Online Comment

Application H09-0796-25
Location Land East of Forest Way Holbeach Spalding
Proposal Proposed Erection of 2 Bungalows

Date Submitted 19-09-25
For/Against Objections

PROPOSED SITE PLAN
scale 1:200

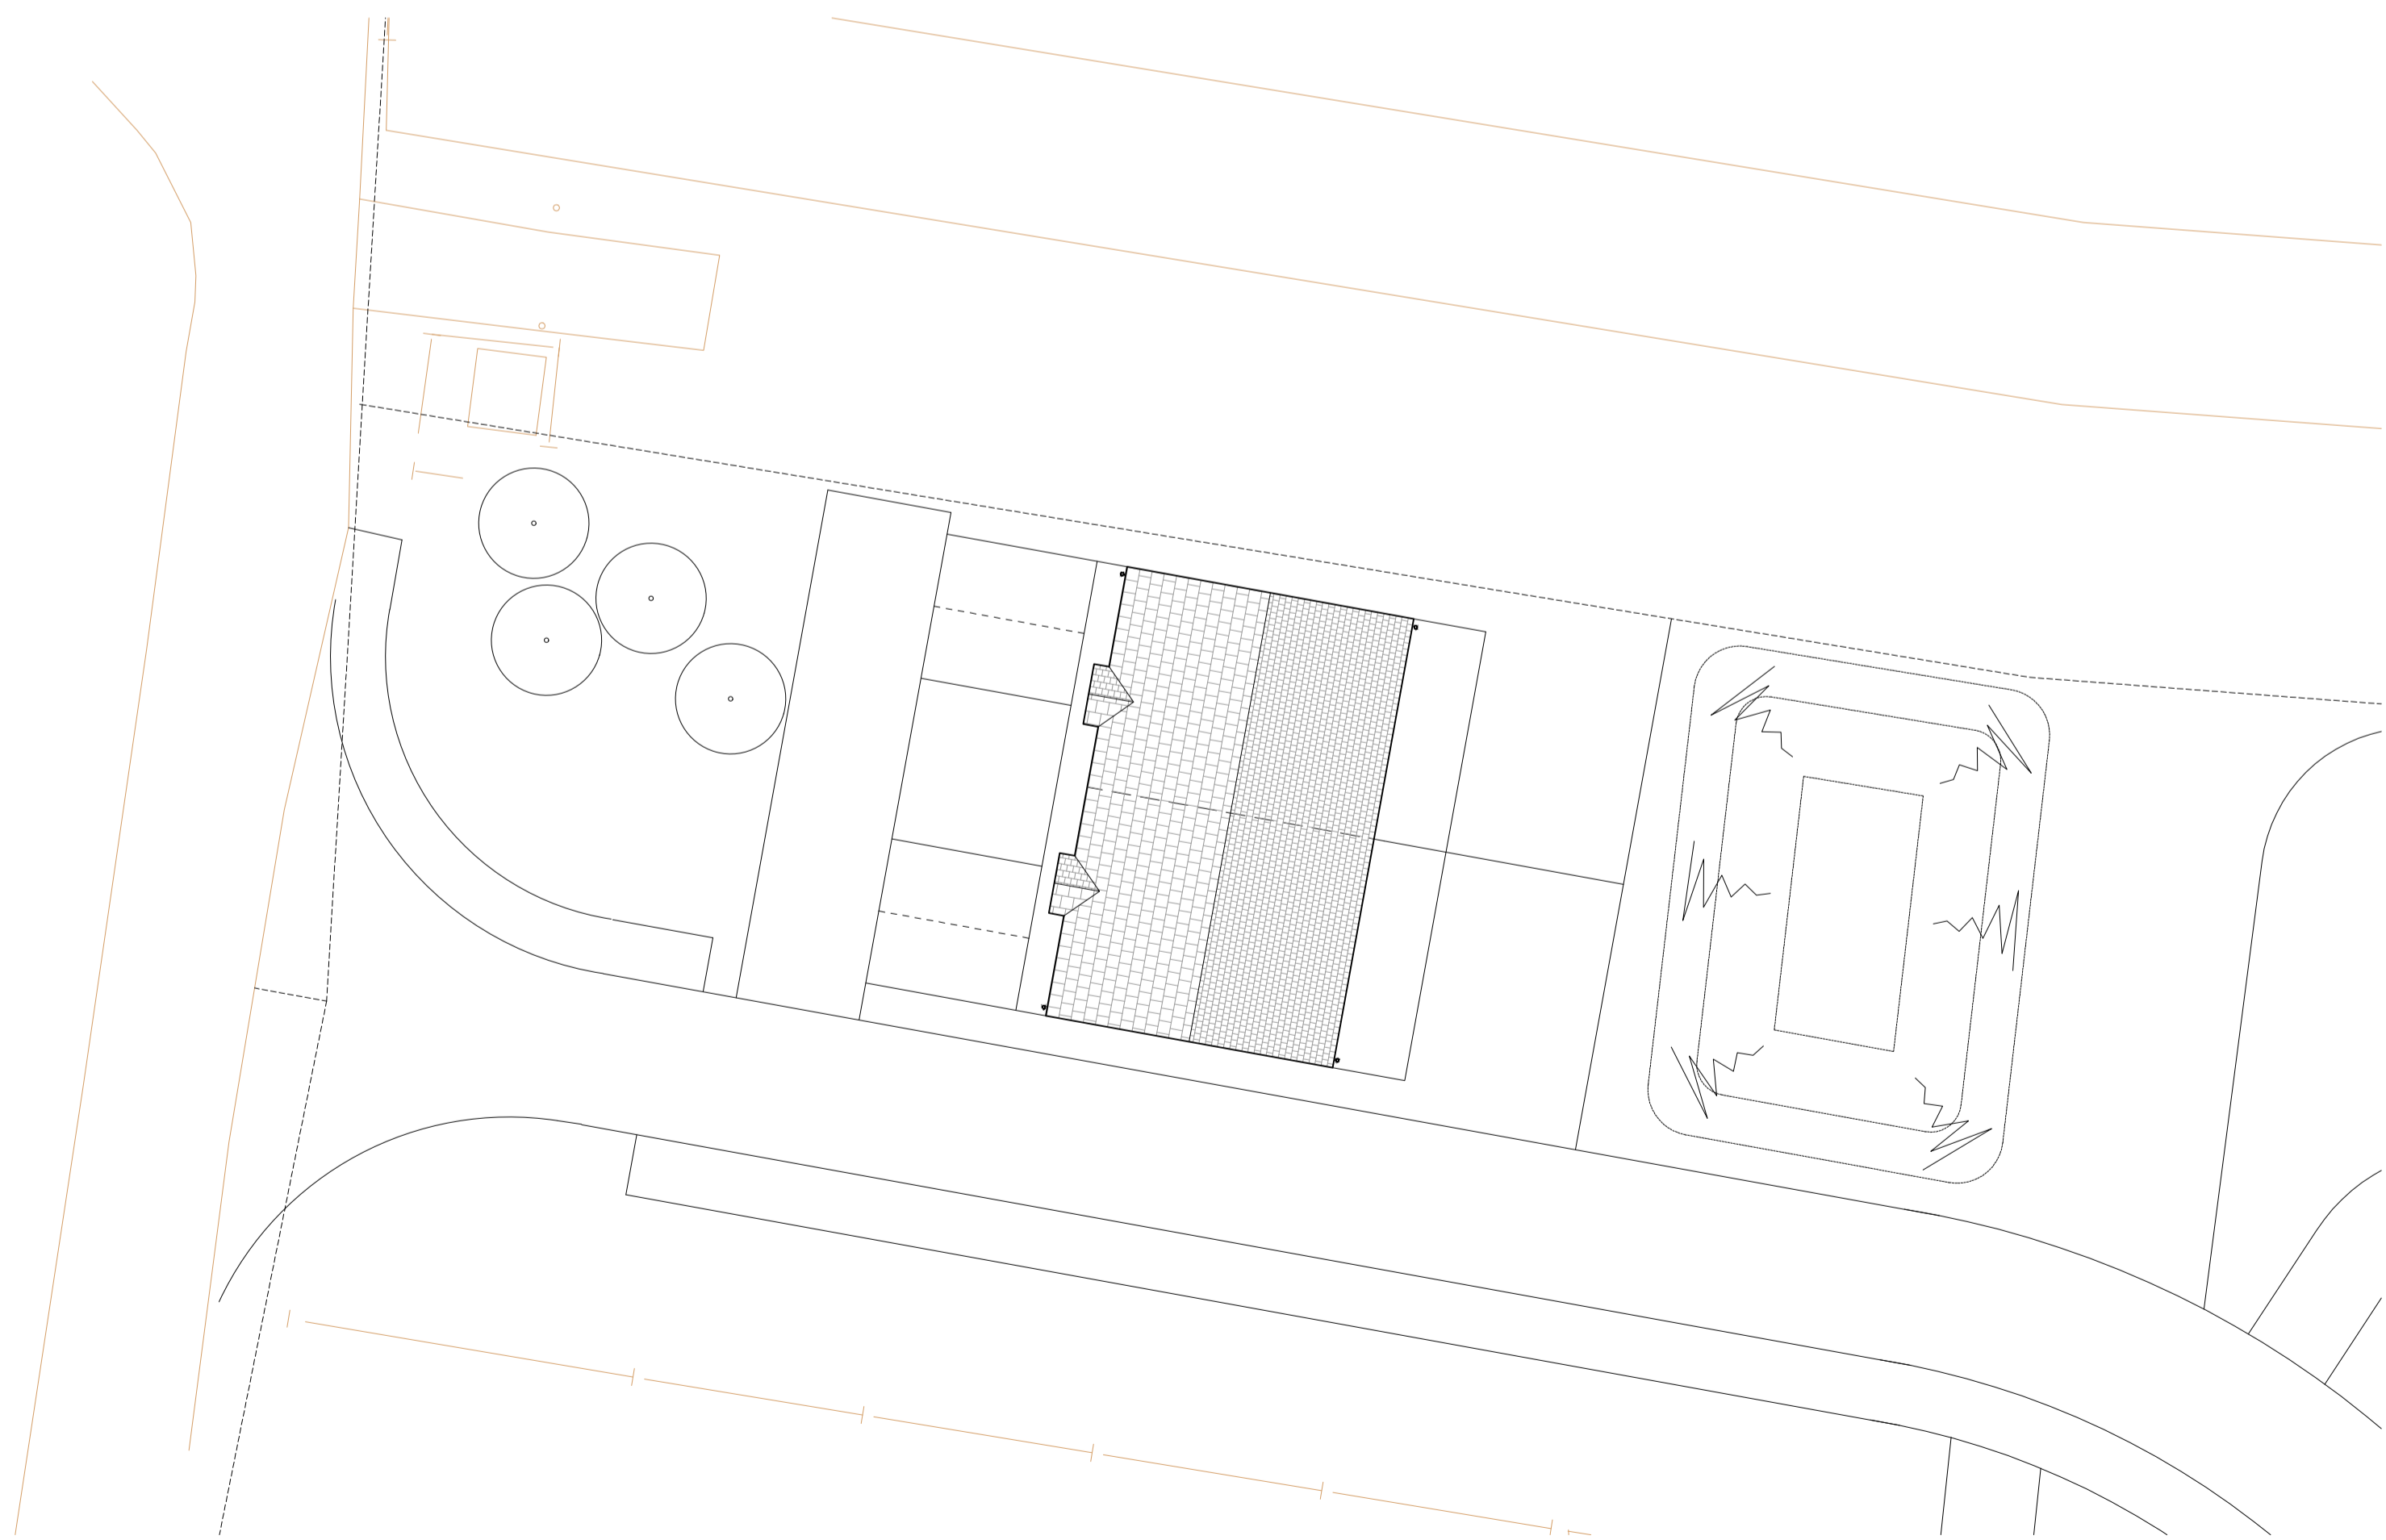
This isn't an application I can support as it will change the aesthetics of the estate. As the green space at the front is in line with the design of another estate close by, I would assume it was part of the original planning application, as this is the green space for the estate. Therefore to add two bungalows is out of keeping with the design, and would limit the green space available to the residents.

Also the entrance to the bungalows is close to the junction, which currently has a fairly clear access view, and the number of dwellings on the estate means that it is a busy road so could cause a problem. There is also the issue that two very small bungalows, with a design that looks very out of keeping with the rest of the properties, each with 2 parking spaces will look completely incongruous dropped onto a space clearly not intended to be built on. I have received 3 objections to the proposal from residents and I'm in agreement with their concerns.
